Approval of details reserved by condition imposed under ref BN/50/20/PL relating to Condition Nos 5 - mitigation method statement, 6 - archaeology, 7 - piling risk assessment & method statement, 8 - Construction & Environmental Management Plan, 9 - foul drainage, 10 - surface water drainage, 11 - maintenance & management of surface water drainage, 13 - pre-commencement site meeting, 15 - odour assessment or evidence that livery has ceased, 16 - soil resource plan, 17 - landscaping, 18 - screen walls & fences, 19 - elevation details of 2 proposed communal bin stores and 20 - colour schedule of materials & finishes.

Land Rear Of 1 Northfields Cottages Fontwell Avenue Eastergate PO20 3RX

Condition Number 17

Arun District Council have decided to **REFUSE details reserved by condition for the following reasons:**

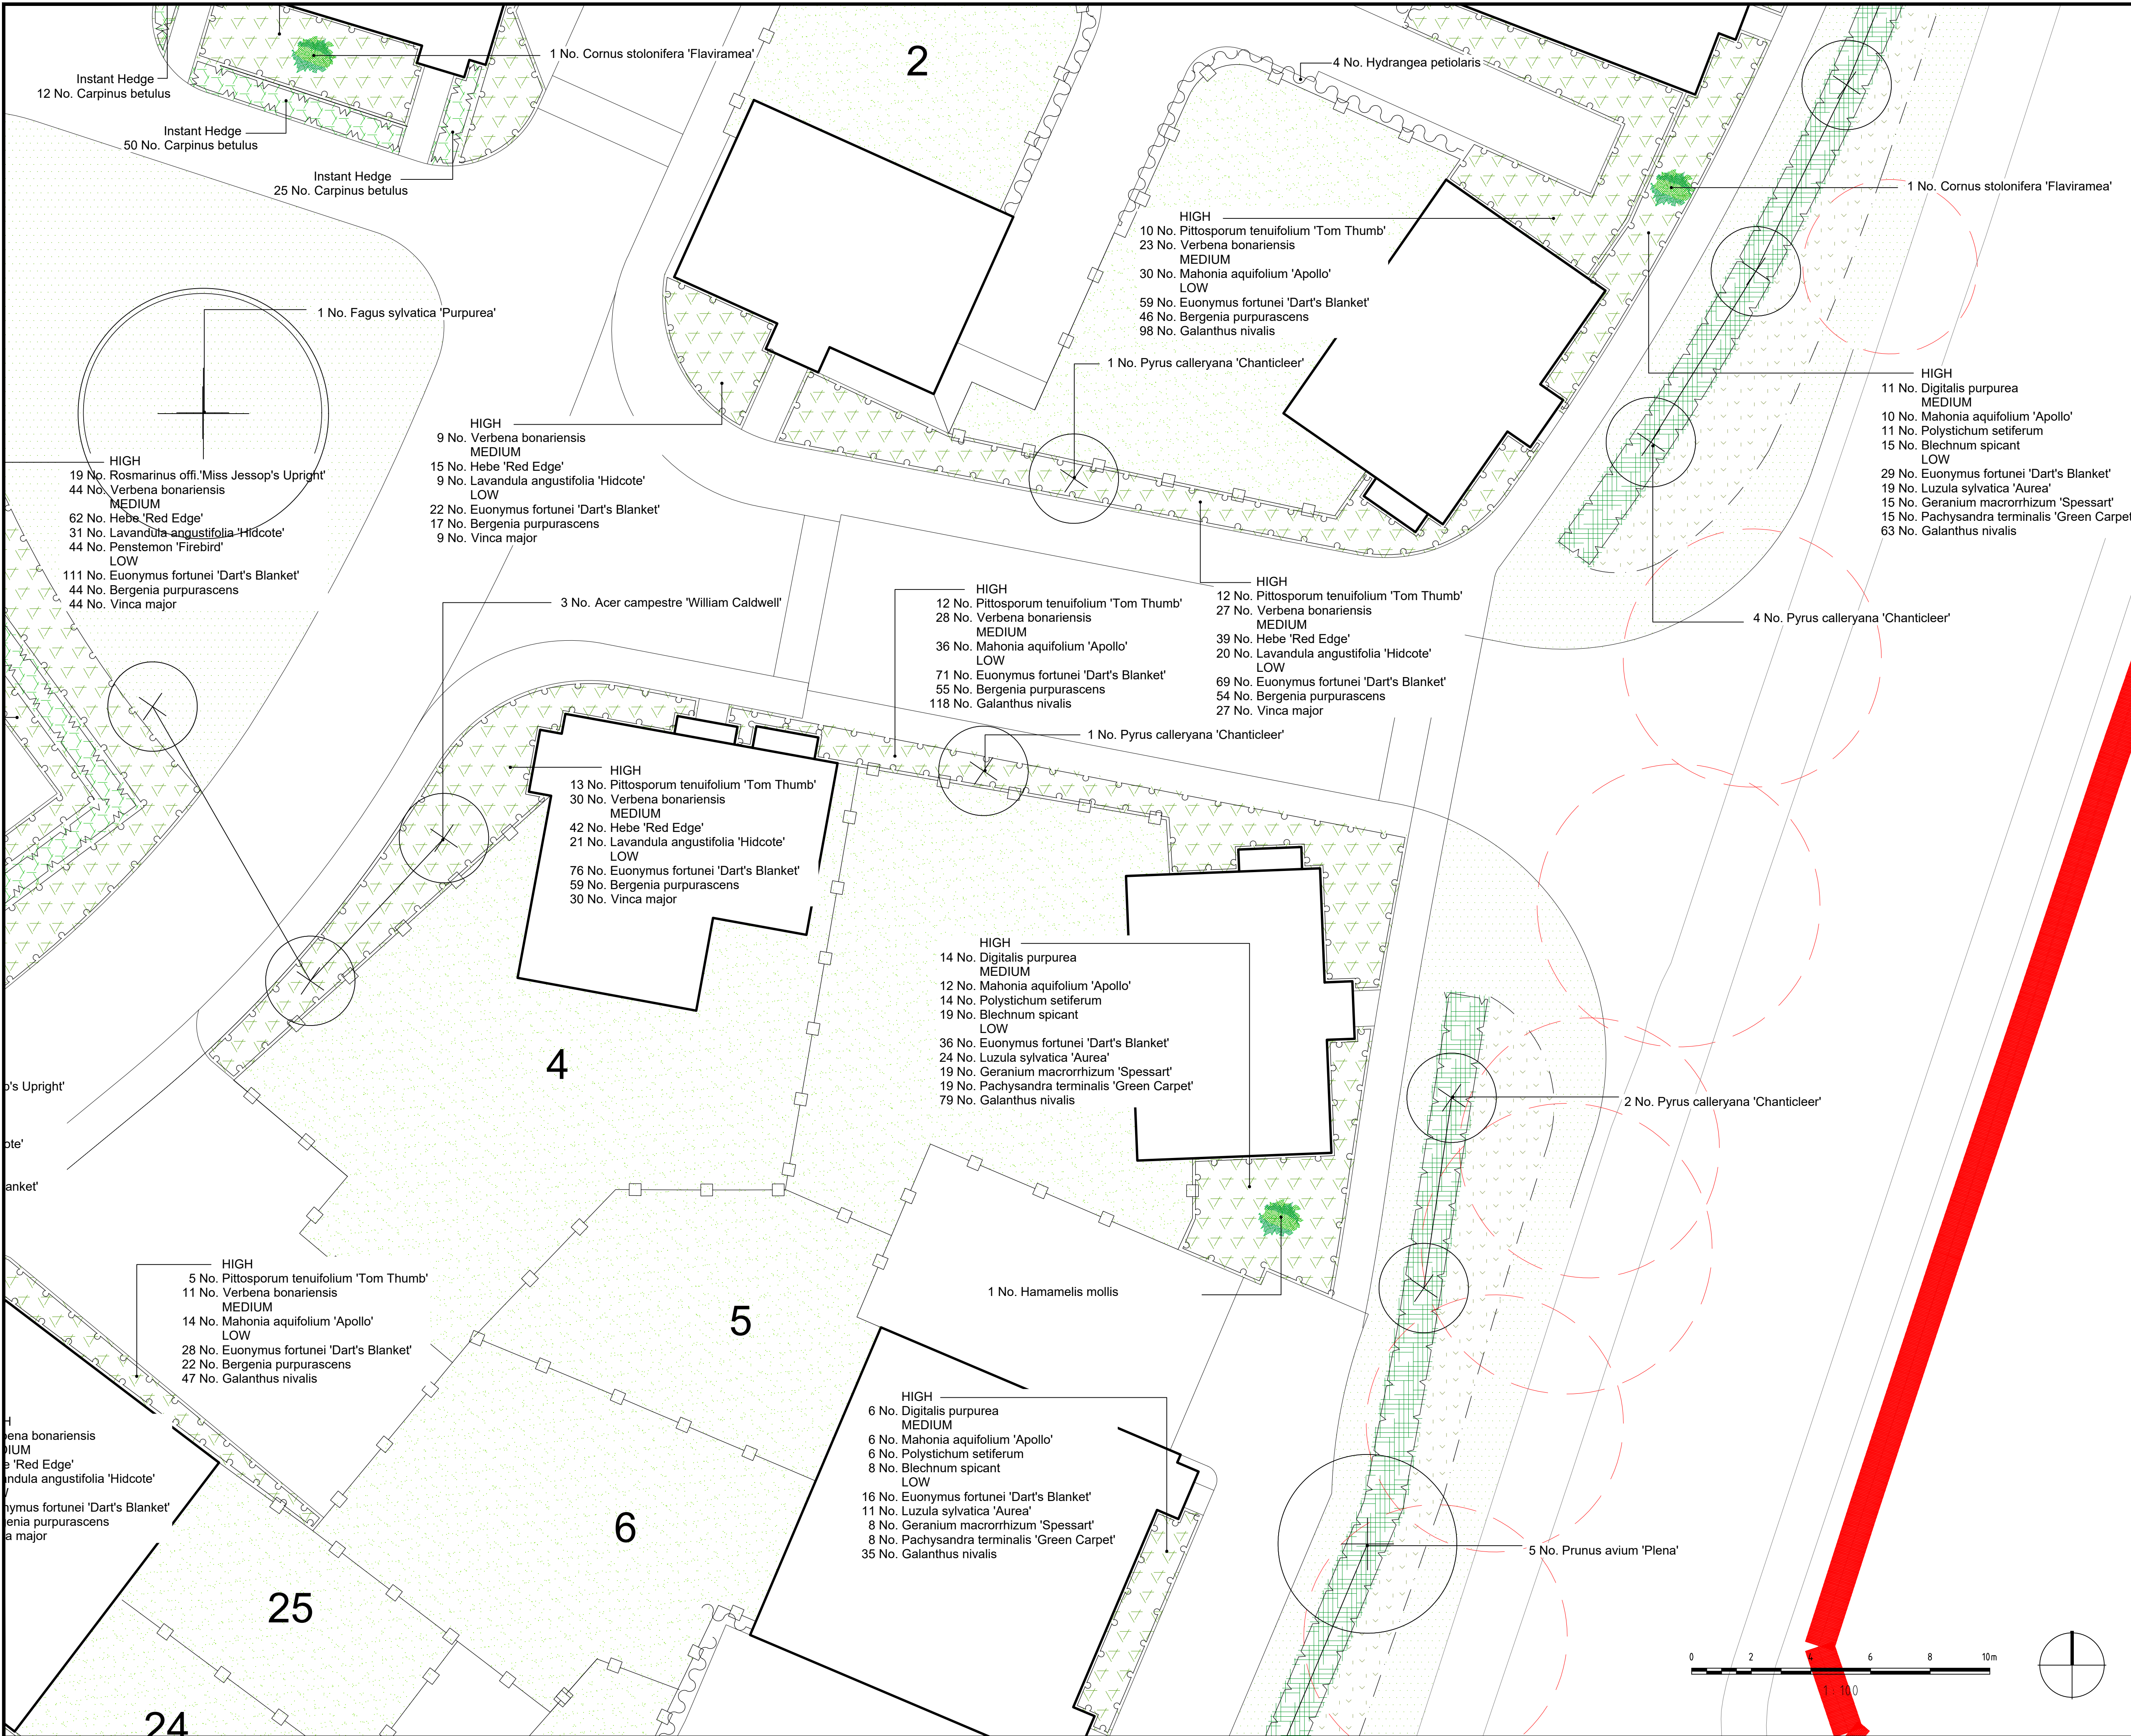
The Council's Landscape Officer has agreed the proposed landscaping scheme but comments that the drawings should be amended to show the previously agreed play provision of timber fitness items into the POS areas to the n/west area of the site.

It is also noted that the landscaping condition requires that at least 26 new native trees are provided to include specimens that will potentially grow to 10-15m high. Large trees are indicated but it is unclear what the height of these will be or how many of the tree species are native. The Landscaping drawing refers the reader to DD504L09 for the planting schedule/matrix and general specification but this does not appear to have been provided.

As such, it is not possible to discharge the condition at the current time and we would invite you to make a resubmission which (a) includes the timber fitness items on the drawings and (b) clearly demonstrates compliance with the specific requirements of the condition.
